**KIRKLEES METROPOLITAN COUNCIL  
INVESTMENT & REGENERATION SERVICE**

**DELEGATED DECISION TO DETERMINE APPLICATIONS FOR  
CONSENT, AGREEMENT OR APPROVAL REQUIRED BY CONDITION**

Reference No:	<b>2024/44/90291/W</b>
Site Address:	2, 4 & 6, Thornton Lodge Road, Thornton Lodge, Huddersfield, HD1 3JQ
Description:	Discharge of conditions 4. (bin storage/collection) & 5. (noise assessment) on previous permission no. 2023/92737 for Prior notification for change of use from shop/restaurant to three dwellings
Recommending Officer:	Laura Yeadon

**DECISION – Partial Approval and Partial refusal of details submitted**

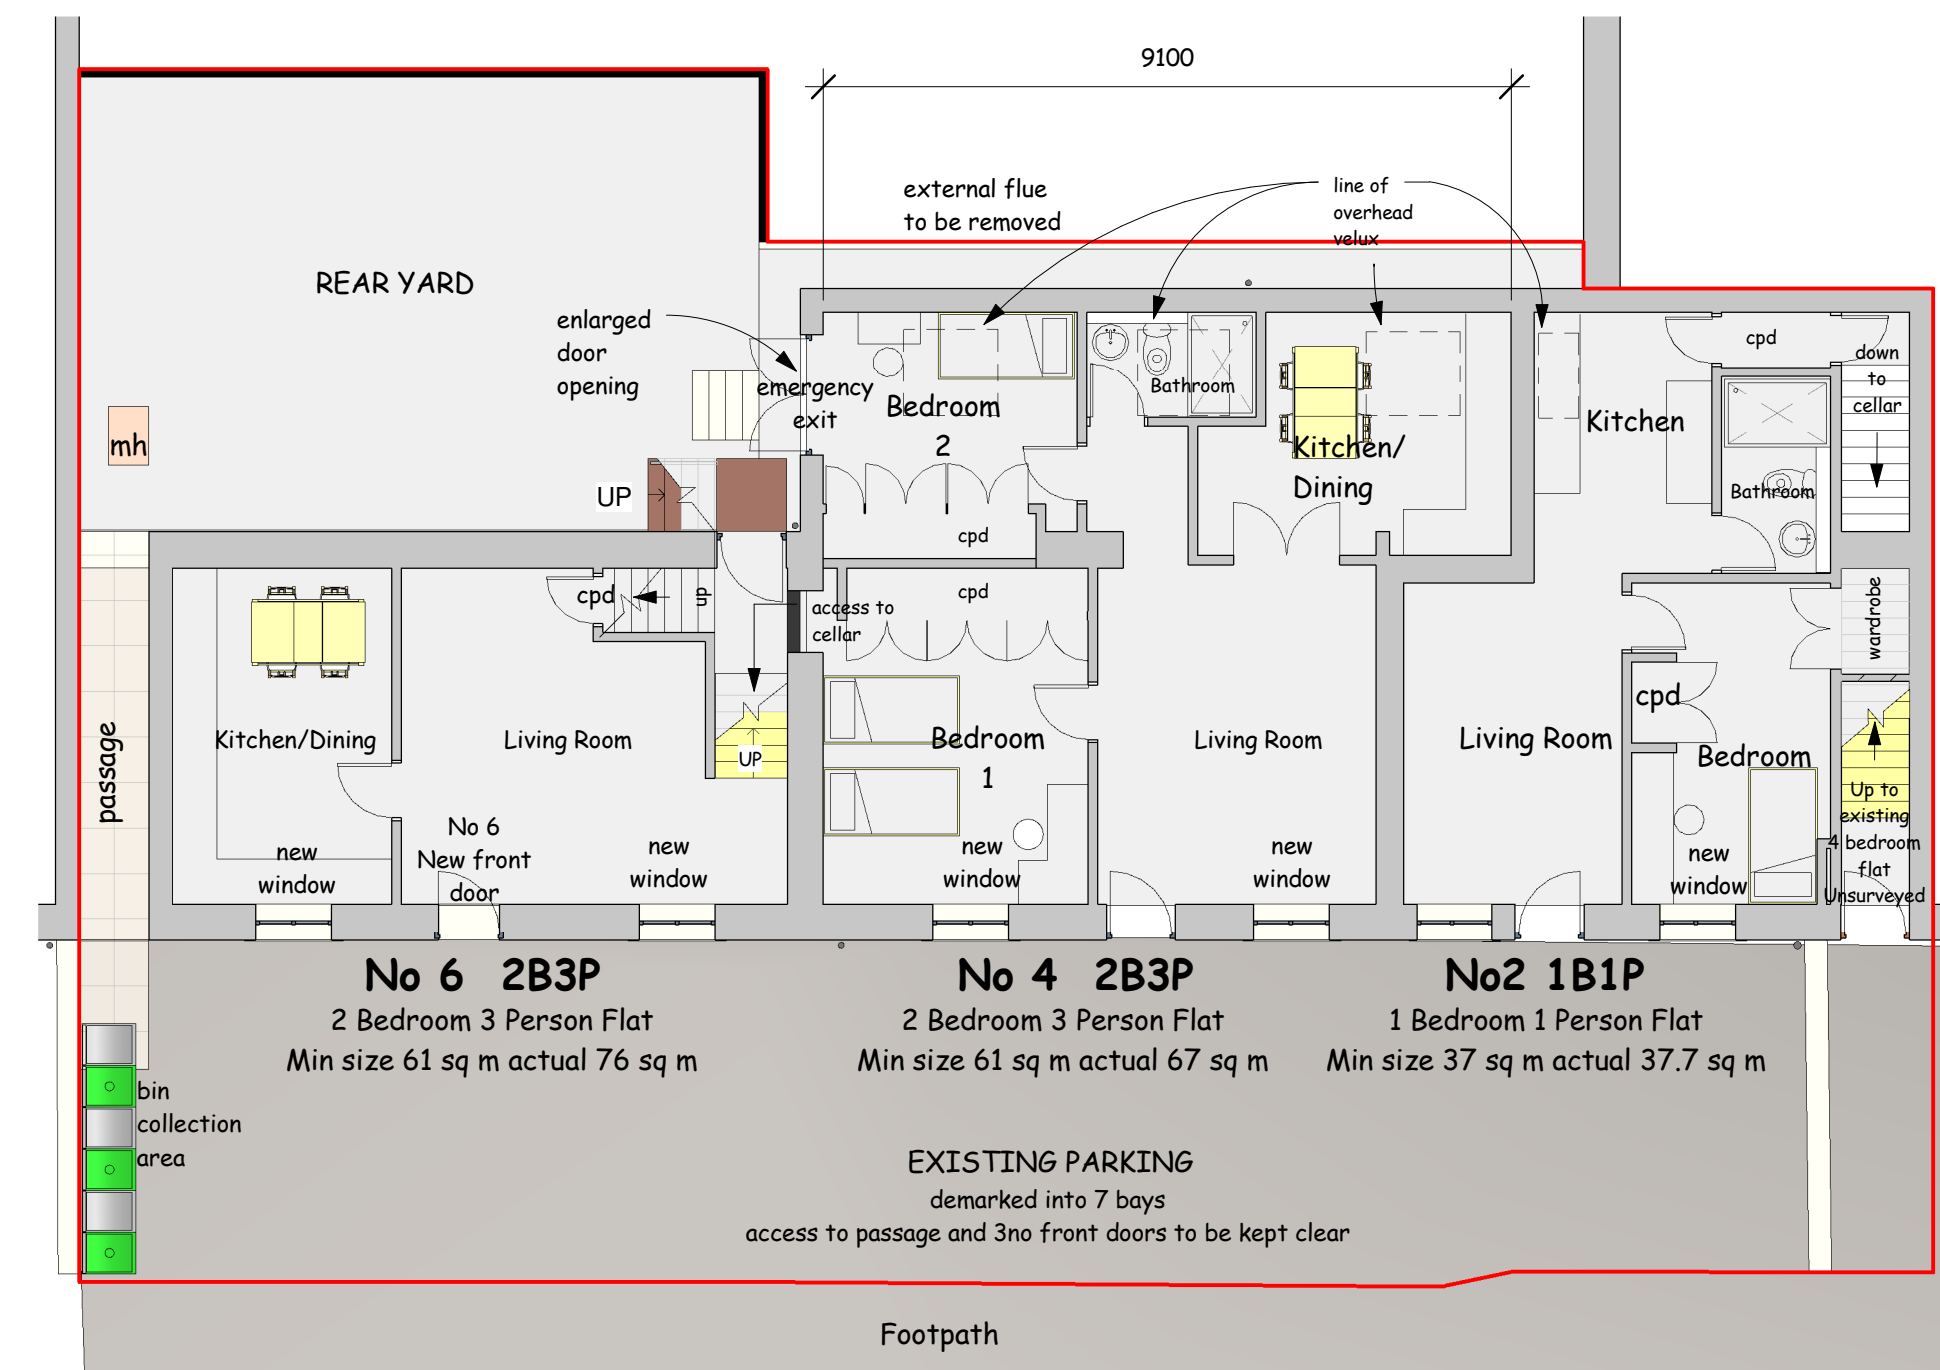
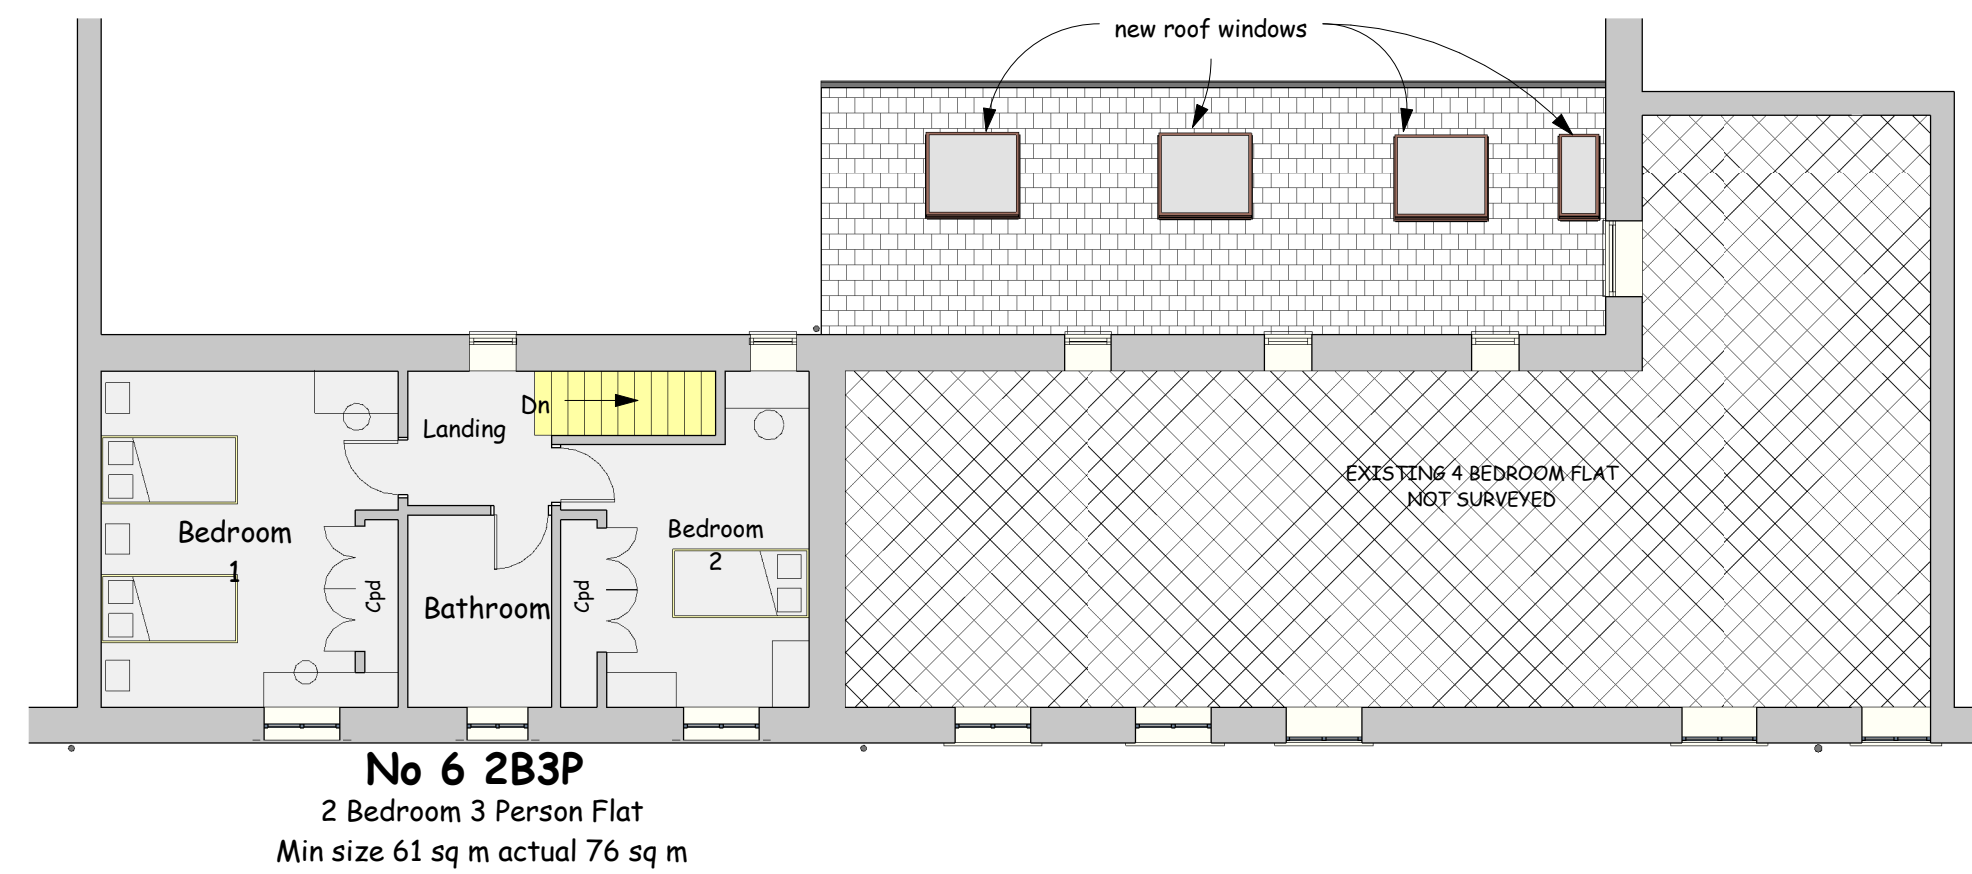
A plan referenced 2304 – 02 – Rev: A has been submitted detailing a bin collection area to the front of the site, adjacent to the parking area of No. 6. Kirklees Waste Strategy Officers have been consulted and have confirmed that the demonstrated collection point is acceptable. However, concerns have been raised regarding the permanency of the storage of bins in this location without permanent screening due to the impact on the street scene, theft, arson or fly tipping.

The plan demonstrates the collection of bin point to the front of the site, adjacent to the parking area of No. 6.

Providing that the storage of bins is to the rear of the dwellings and the bins are presented at the collection point on collection day in the area demonstrated on the submitted plan and retained as such, free of obstruction, this condition shall be satisfied.

Providing that the storage of bins is to the rear of the dwellings and the bins are only presented at the collection point on collection day, in the area demonstrated on the submitted plan and then returned to the rear of the site - and these arrangements retained as such, free of obstruction, this condition shall be satisfied.
